LAND AT SALT BOX, BOGNOR REGIS

INDEPENDENT REVIEW OF SURFACE WATER SYSTEM

Date: 28 October 2021

Doc ref: SAL-HYD-R-C-GLOS-0001

UNIT 2 FC-201
FLOW CONTROL IN CIRCULAR MANHOLE
SCALE 1:20
(REFER TO C-7010 FOR LOCATION)

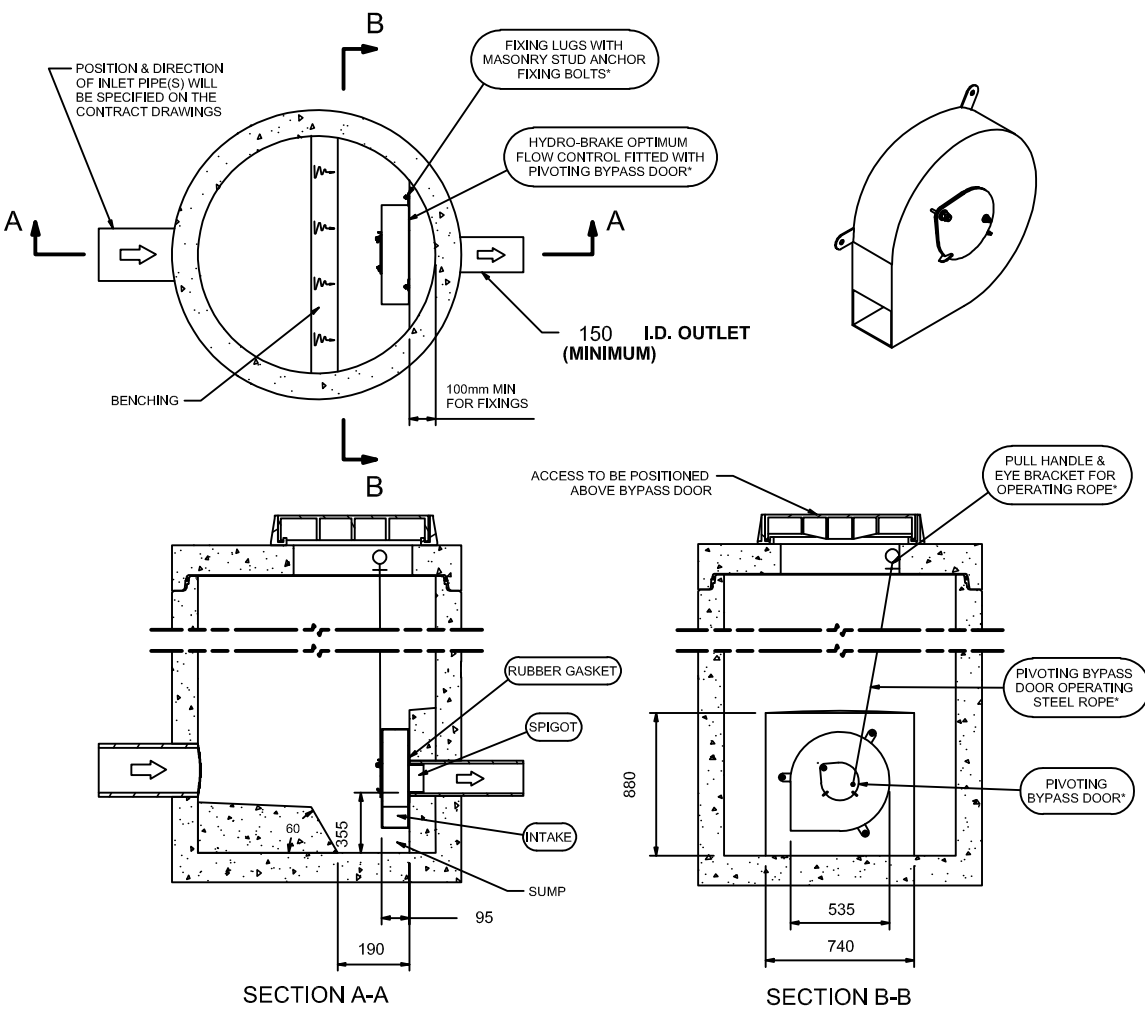
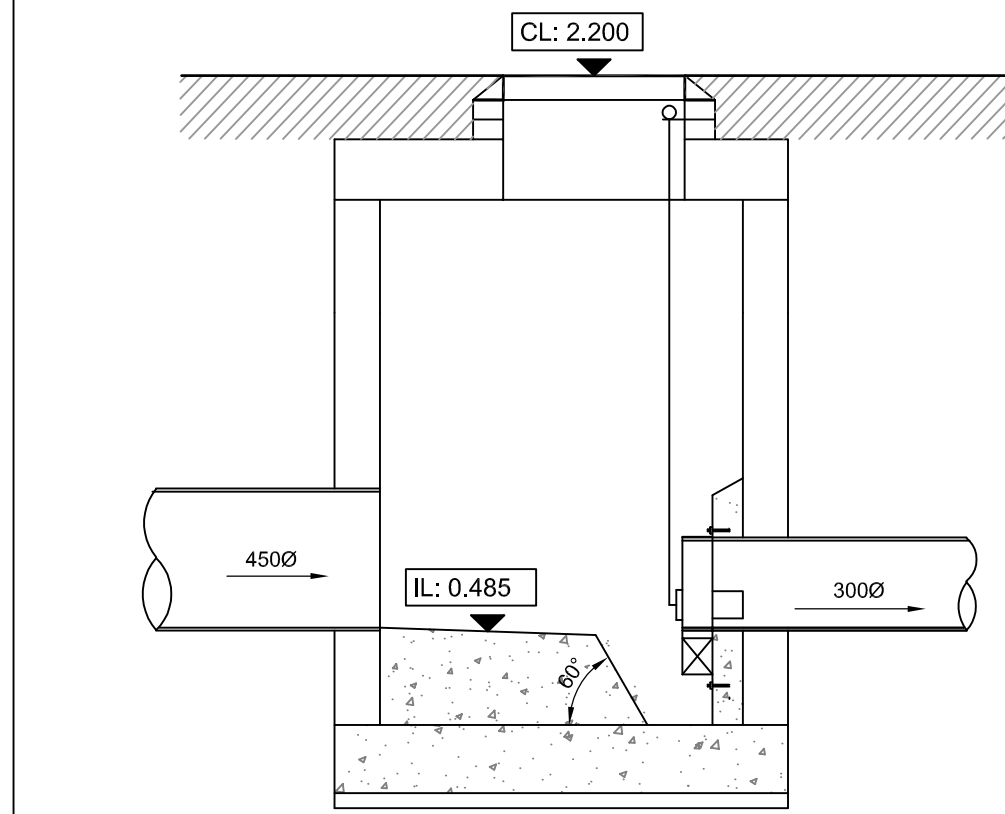
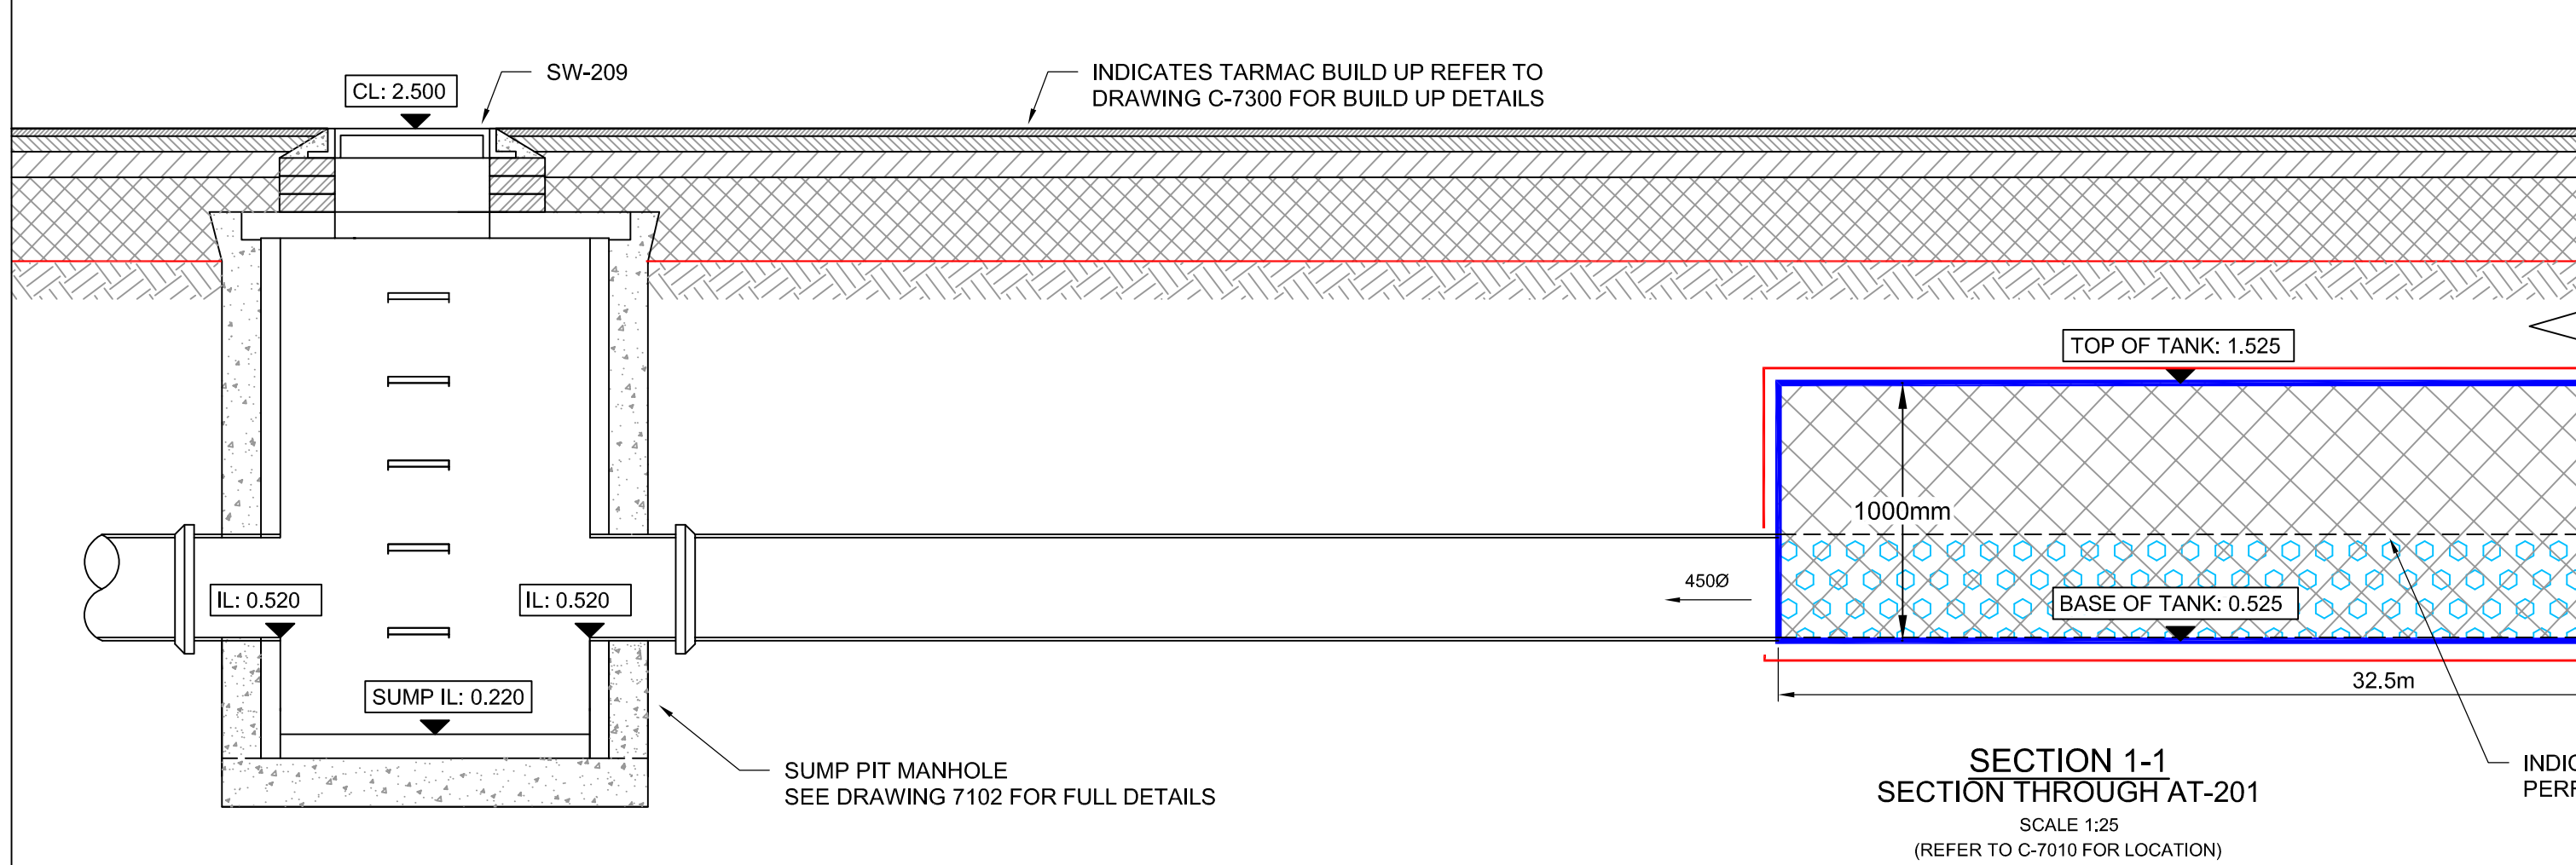
6. SW 504 ADBLY manhole reference incorrect, differs from Hydrock as built drawing
7. SW 505 ADBLY manhole reference incorrect, differs from Hydrock as built drawing

8. FC 501 ADBLY manhole reference incorrect, differs from Hydrock as built drawing
9. SW 901 to 903 length of runs excessive, confirm this is acceptable for maintenance

- a. Updated to suit. *[Refer to Appendix L]*
6. SW 504 ADBLY manhole reference incorrect, differs from Hydrock as built drawing
 - a. Noted.
7. SW 505 ADBLY manhole reference incorrect, differs from Hydrock as built drawing

- a. Noted.
8. FC 501 ADBLY manhole reference incorrect, differs from Hydrock as built drawing
 - a. Noted.
9. SW 901 to 903 length of runs excessive, confirm this is acceptable for maintenance
